Hollystown - Kilmartin SHD Dublin 15

Infrastructure Design Report

170182-DBFL-XX-XX-RP-C-007

As part of the pre-application process, FCC Water Services Section prepared two reports on the pre-application submissions for the Hollystown Sites 2 & 3 (An Bord Pleanála Ref. No. ABP-309926-21) and for the Kilmartin Local Centre (An Bord Pleanála Ref. No. ABP-309783-21). We note the responses to the Transportation Section are included in the TTA report

PLAN OF TYPICAL ABOVE GROUND
ATTENUATION STORAGE
SCALE 1:250

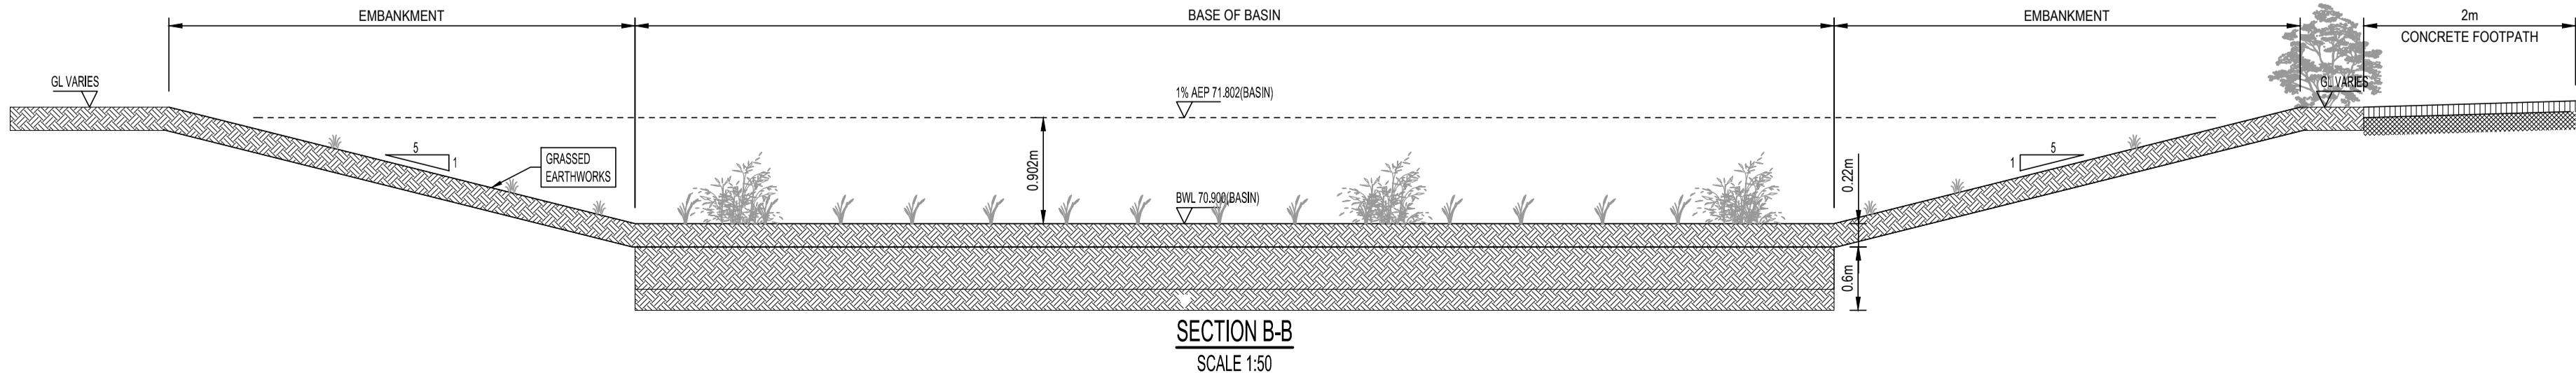
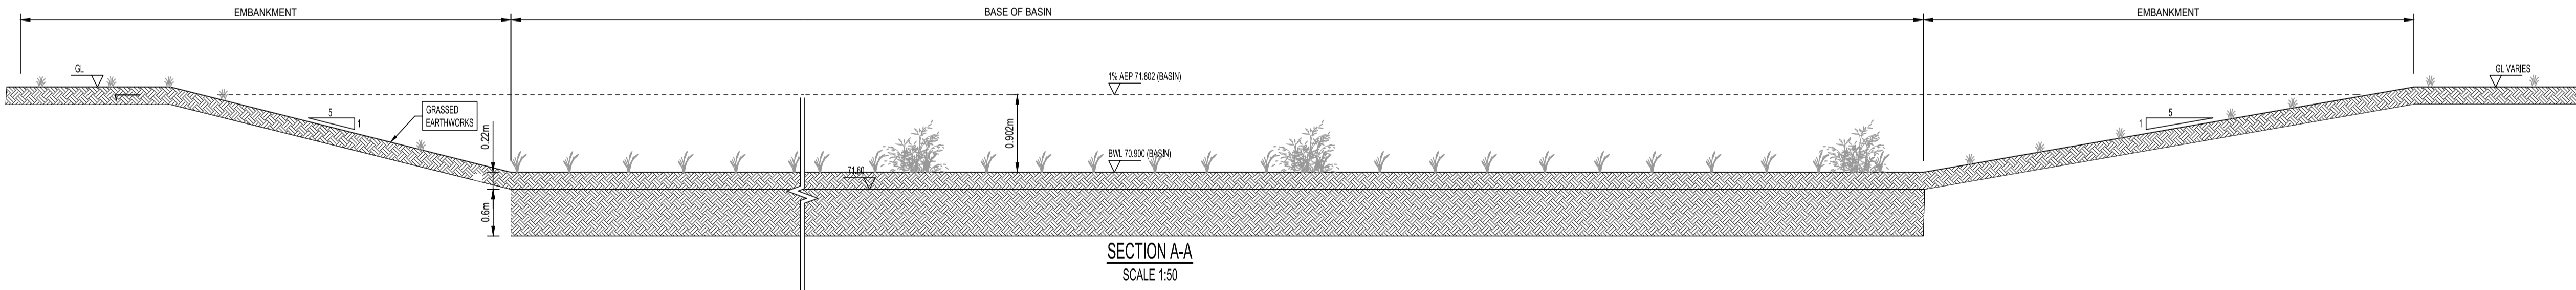
e. There is a general concern regarding the shape, depth and proximity of basins to footpaths, roads and structures. The applicant is requested to prepare detailed green/blue drawings and also sections demonstrating the above relationships.

As agreed with FCC Parks and Water Services we have emended the shape of the basins to ensure that the side slopes of the basins are max 1 in 5. As requested, we have also provided a 2m flat area at the top of each basin to allow for grass cutting. Please refer to DBFL Drawings 170182-DBFL-CS-SP-DR-C-1004 to 1007 and 170182-DBFL-CS-SP-DR-C-1011 for plans and DBFL Drawings 170182-DBFL-CS-SP-DR-C-5301 to 5307 for sections which are submitted as part of the planning application.

PLAN OF UNDERGROUND SURFACE WATER STORAGE SYSTEM
(SCALE 1:250)

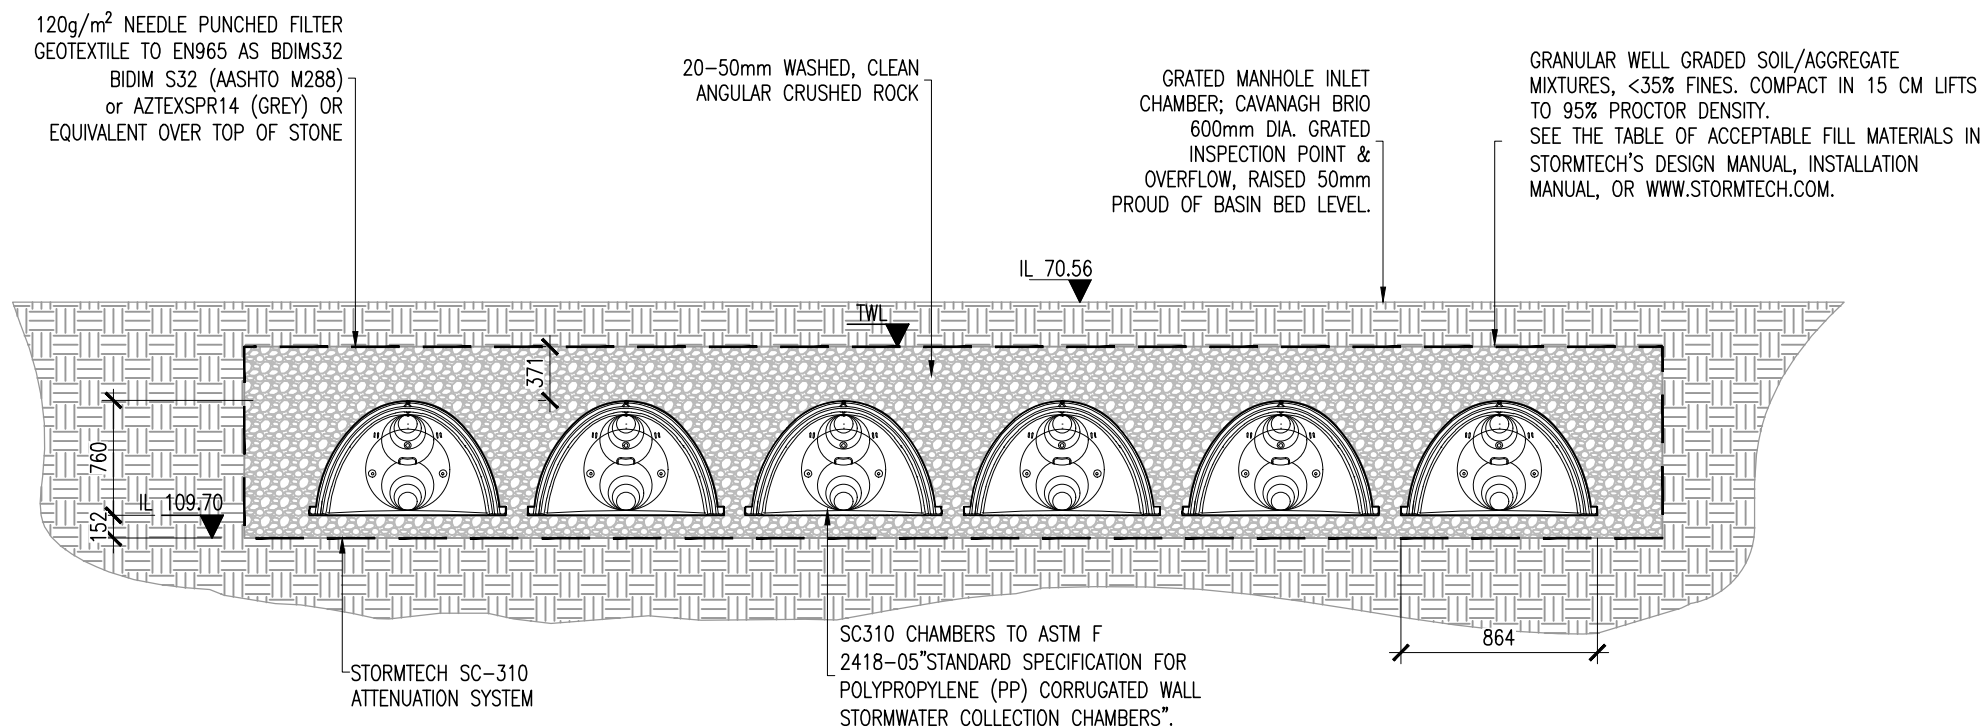
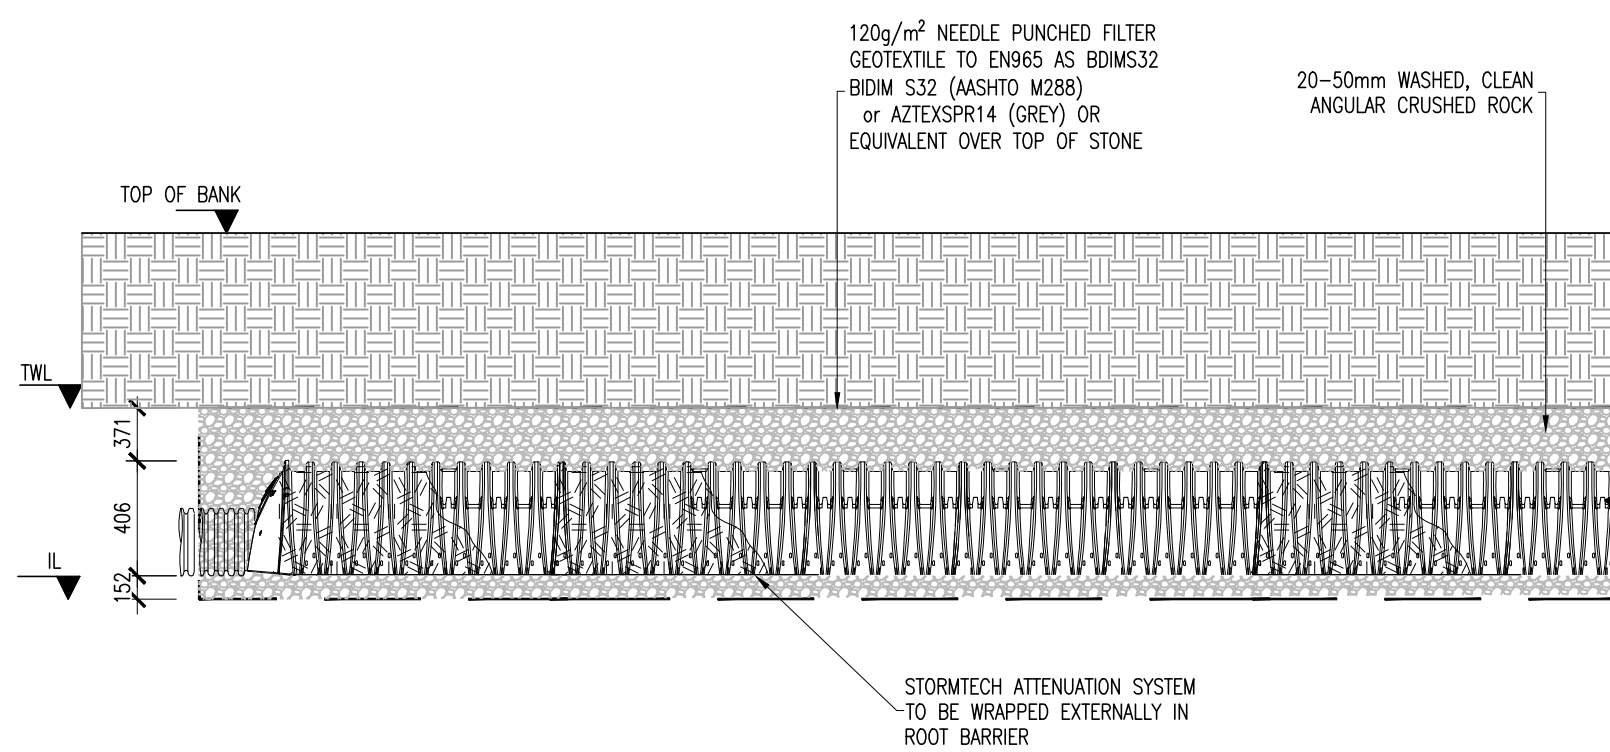
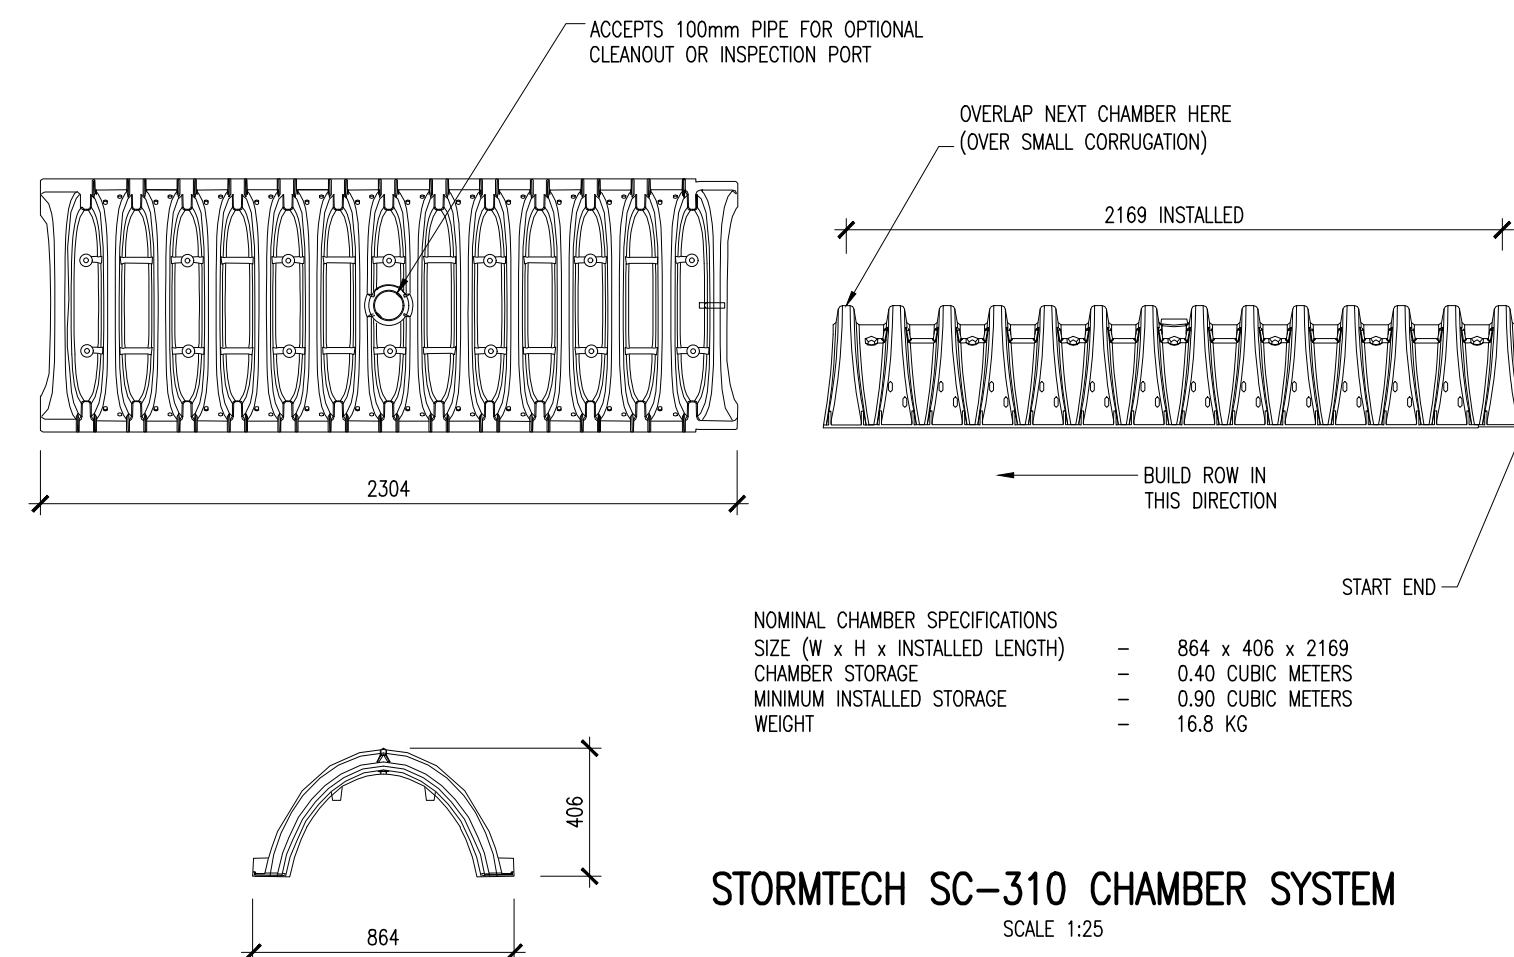
d. The applicant should note that Stormtech units are generally not Taken-in-Charge. However it is acknowledged that their use may be justified in certain situations. To this extent the applicant is requested to prepare a comparative review of Stormtech v natural drainage stone with regards to each of the four areas where underground attenuation storage is being proposed. Similarly there may be overshadowing benefits associated with using Stormtech elsewhere in

order to provide for more natural detention depressions. This should be investigated and discussed with Parks and Operations.

Generally detention / infiltration basins, swales, tree pits are provided throughout the vast majority of the scheme as agreed with both FCC Water Services and Parks Departments. As noted above there are 4 areas where underground storage has been provided. We have proposed a stone build-up underneath the 2Nr Swales / Basins along the western boundary of Site 3. This is due to the narrow space available here and the fact that we could provide sufficient storage using the stone build-up in this area. In the other 2 areas we have chosen the 2Nr Stormtech Geo-cellular attenuation systems as opposed to natural drainage stone due to the fact that these systems have a much higher porosity than natural stone and, therefore, require significantly less land take. It is our opinion, that the use of stone for underground storage of surface water in these higher volume areas is not a sustainable method of storing surface water, due to the volume of material to be excavated, disposed of and the volume of material to be imported and the maintenance of same. The volume of stone and area of the system required would be over twice as much for the stone build-up as opposed to Stormtech. The maintenance of the Stormtech Geo-Cellular Attenuation Systems is also much simpler than that of natural drainage stone as outline below. Also, If we were to provide basins in these areas, we would end up with very deep unusable open space areas that would need to be fenced off.

In terms of maintenance, 'Stormtech' units are easily inspected and maintained to assure a properly functioning stormwater system. Inspection is through a manhole or inspection port on the 'Isolator Row'. Inspection ports allow inspection from the surface without the need for confined space entry. If sediments are found to have accumulated to a depth of 76mm, cleanout of the 'isolator row' using 'JetVac' maintenance is required. As noted above, underground storage using stone cannot be inspected or easily maintained, i.e., any build-up of silts is not visible and cannot be removed without excavating and removal of the system.

It should also be noted that 'Stormtech' units are Certified, are used industry wide and are routinely taken in charge by Local Authorities. They are designed to provide treatment of water through the removal of contaminants (CIRIA SuDS Manual 2015) and is a recognised SuDS feature. The Isolator row in the 'Stormtech' unit is a first-flush treatment device and the 'Stormtech' unit itself, is a SuDS Infiltration System as defined in the GDSDS.
